**WELWYN HATFIELD BOROUGH COUNCIL – DEVELOPMENT MANAGEMENT**  
**DELEGATED REPORT**

<b>APPLICATION No:</b>	<b>W6/2012/0766/EM</b>
------------------------	------------------------

The application seeks consent for the erection of a single storey rear extension.

Drawing No.	A100	Checked	-
-------------	------	---------	---

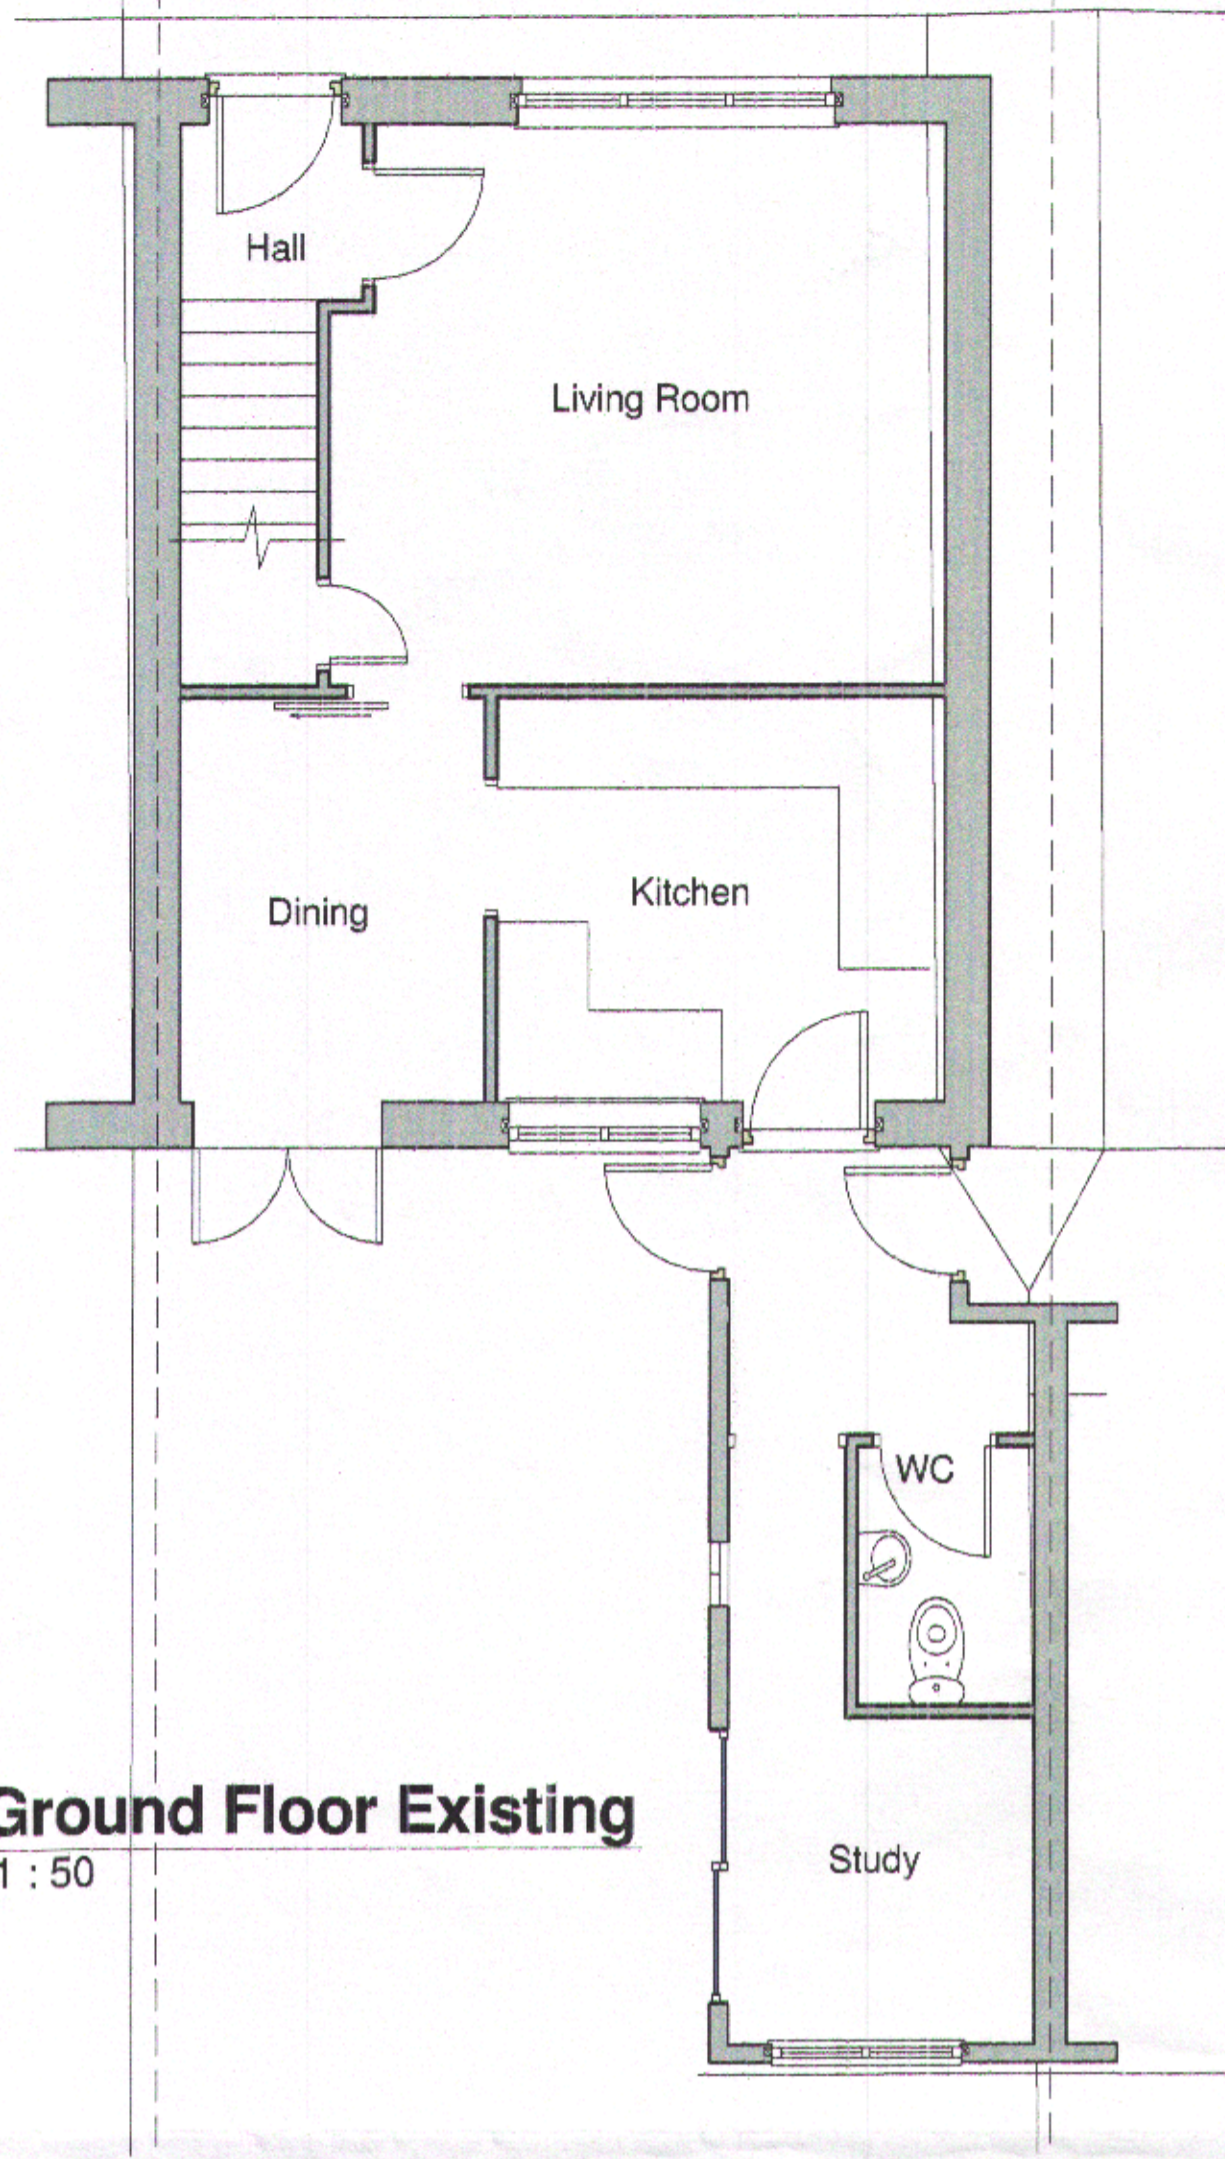
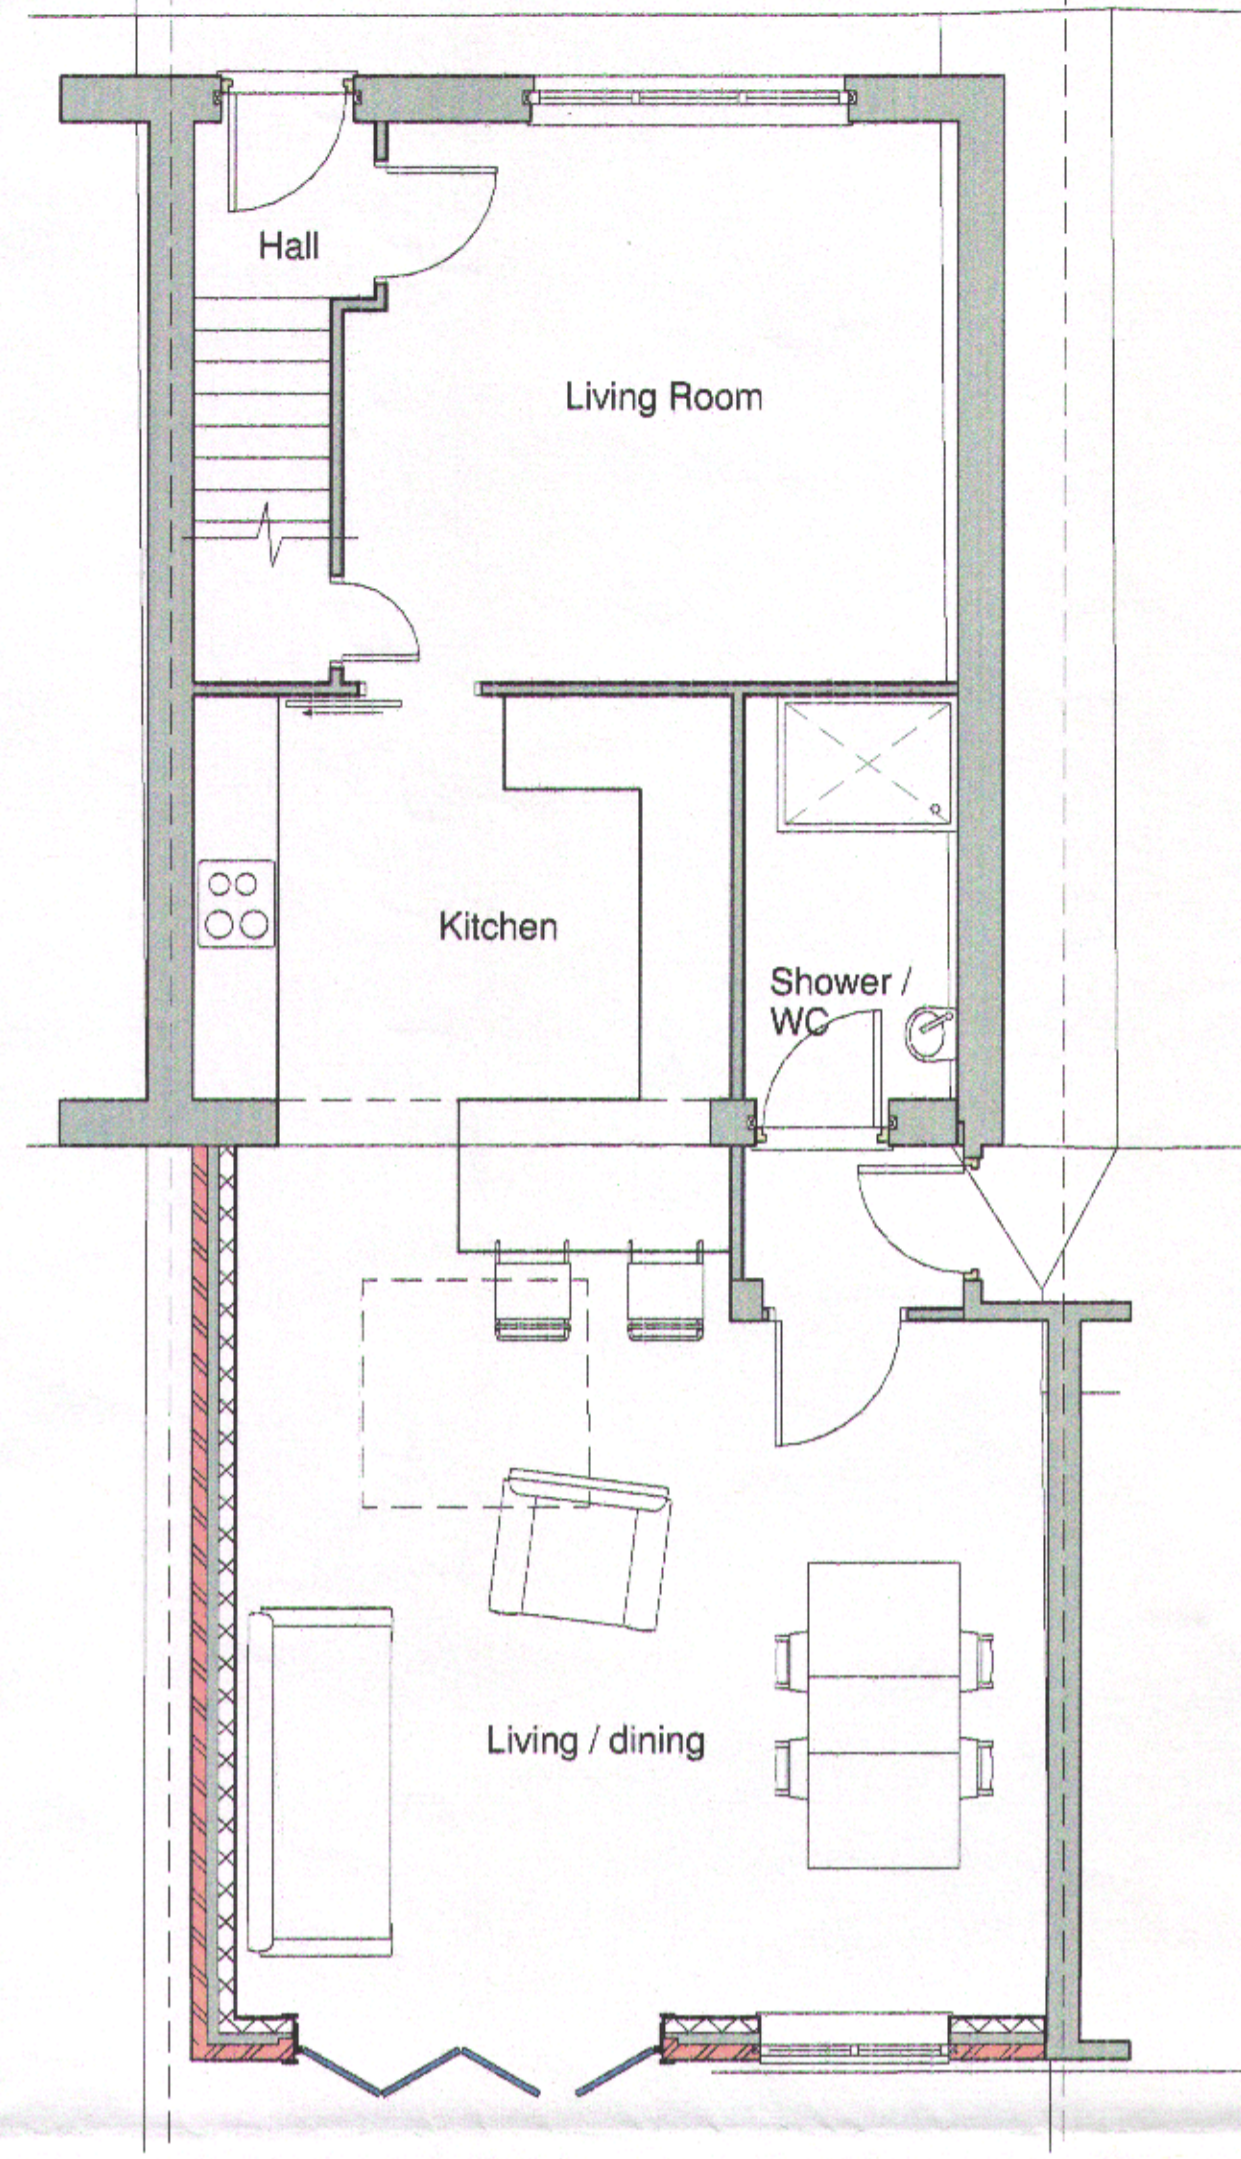
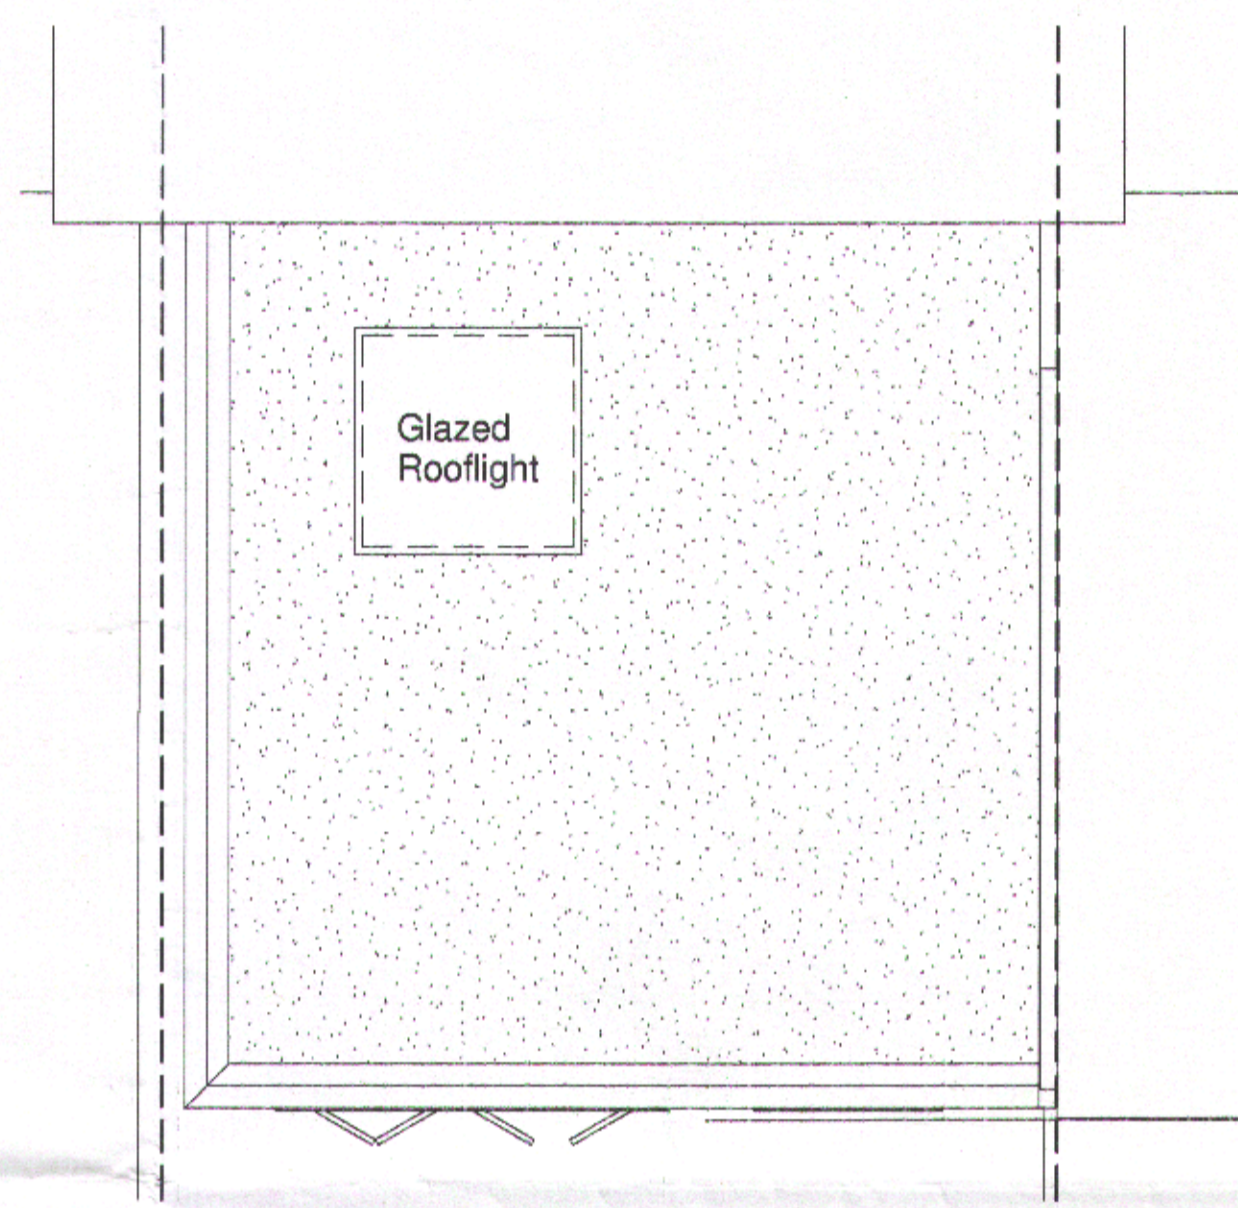
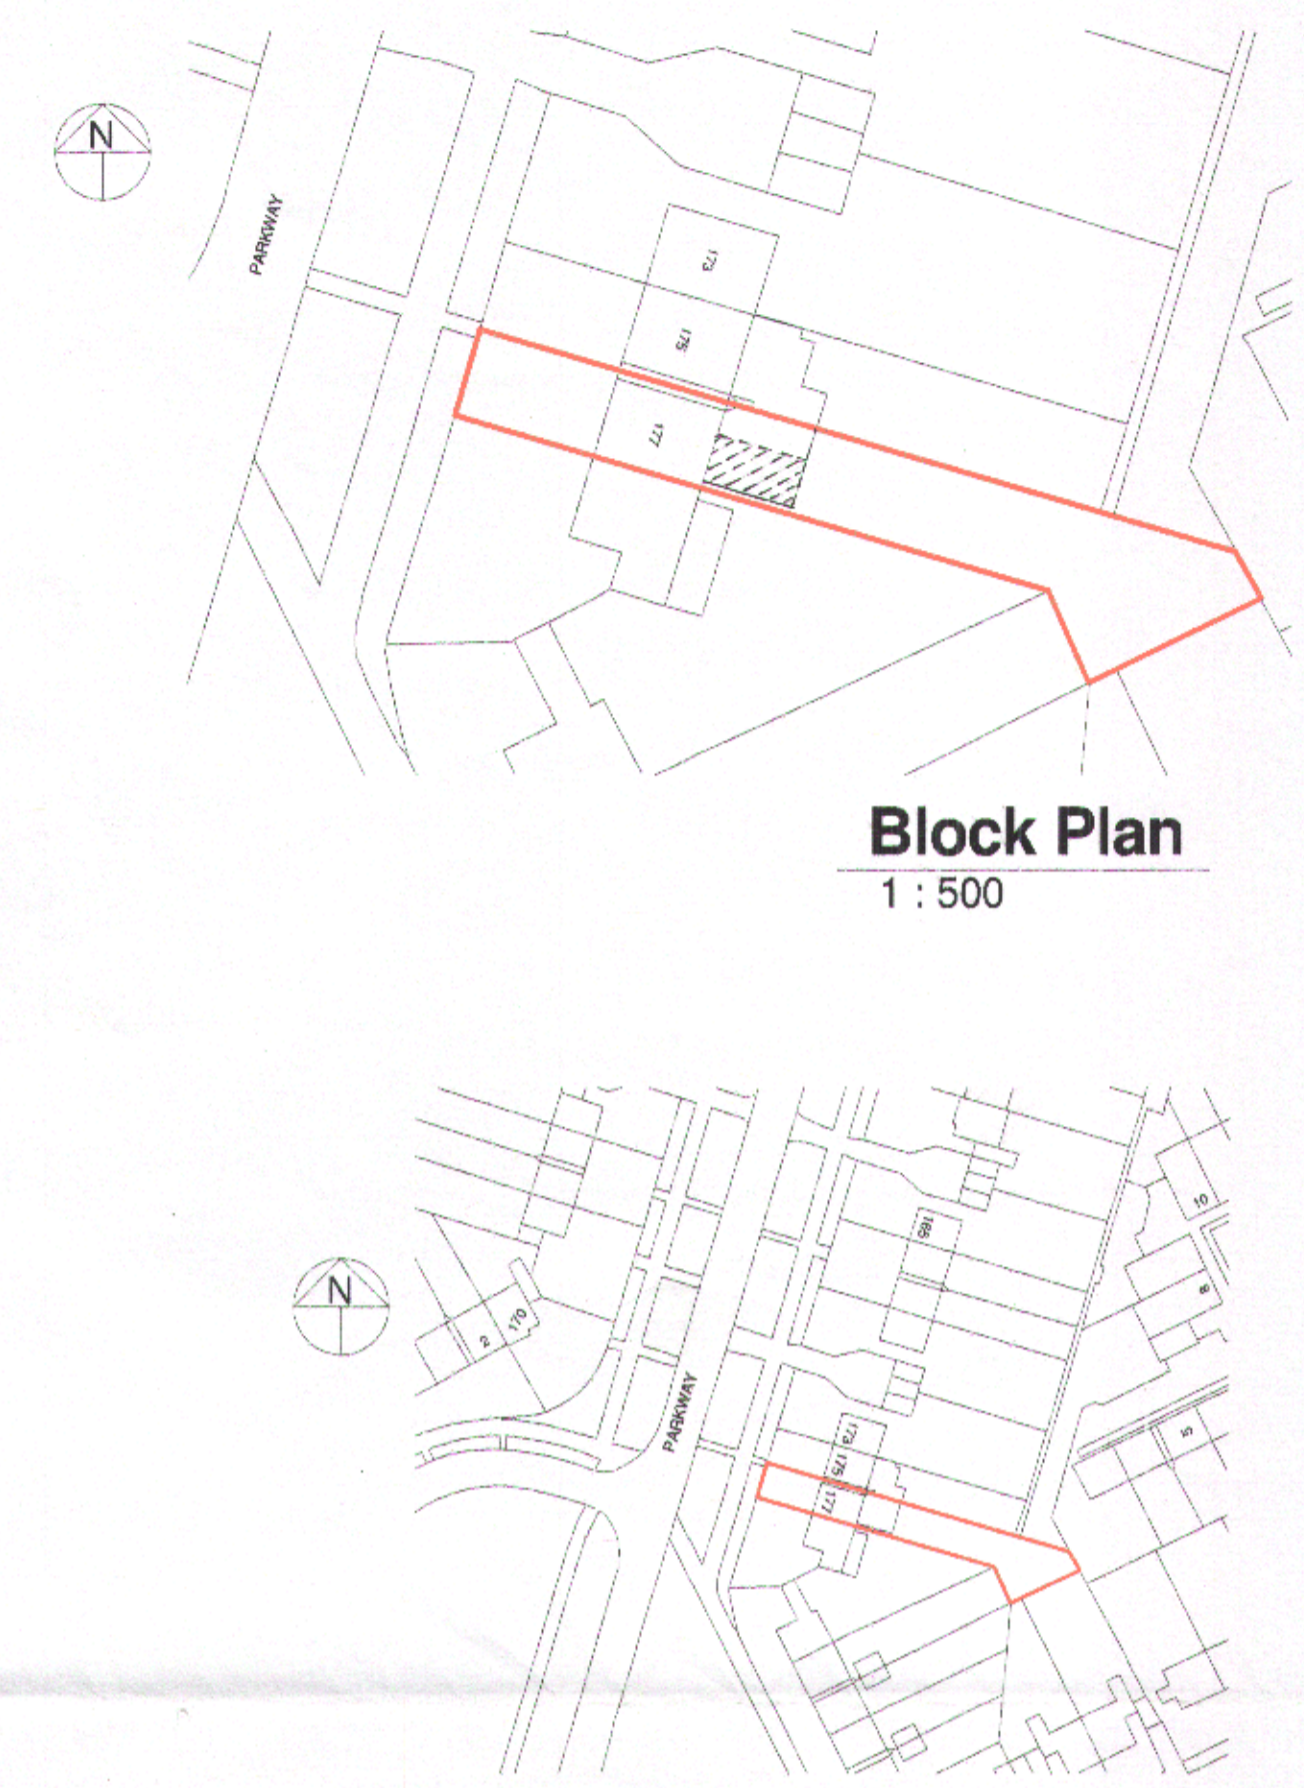
The property is a mid terrace dwelling in a row of four. The property has an existing single storey rear extension alongside the boundary with No. 175 which is the same depth as the extension proposed. This only has a width of approximately 2.3m. The proposed development seeks to form an extension which would extend basically across the full width of this dwelling for a depth of approximately 6m. As a result of the size, design and location deep into the garden, the proposed new development would be excessively large and would not appear subordinate in scale to the original dwelling. It would stand out amongst the surrounding back gardens as an unduly bulky and alien feature when viewed from the nearby properties. Consequently the proposed development would detract from the value and amenities of the garden city, contrary to the Policy EM1.

With regard to its detailed design and appearance, it has been designed with a flat roof which is characteristic of the garden city. It would be constructed from materials to match the existing and the fenestration, whilst not entirely reflective of the fenestration in the existing dwelling, given its location at ground level no objections are raised.

With regard to No. 179 Parkway, this property has a small rear extension which projects into the garden by about 2m. Given the depth of the proposed extension, which would be about 6m, it is considered that whilst there would be a limited loss of light given the height and siting of the extension, it is considered that it would project unduly into the rear garden and would appear overbearing and unduly prominent

from the rear of No. 179 Parkway to the detriment of the residential amenity of the occupiers of this property.

The proposed development would result in an excessive depth of built form from the original rear wall of the property which would fail to remain subordinate in scale to the original form of the property. In addition, the proposal would appear intrusive and overbearing from the rear of no. 179 Parkway to the detriment of the residential amenity that they should reasonably expect to enjoy.

1. The proposed extension, by virtue of the amount, scale, bulk, depth and design of development proposed would not be subordinate to the original dwelling and would result in an incongruous addition that fails to be in keeping and respect the original dwelling. The proposed development would therefore fail to preserve the unique architectural heritage of the building and would detrimentally impact on the amenities and values of the surrounding area contrary to the principles and policies of EM1 of the Estate Management Scheme.
2. By virtue of the location, depth and height of the proposed extension, it would appear visually intrusive and overbearing to the windows and private rear garden at No.179 Parkway to the detriment of the residential amenity of the occupiers of this property. The proposed development would therefore be contrary to Policy EM1 of the Estate Management scheme.
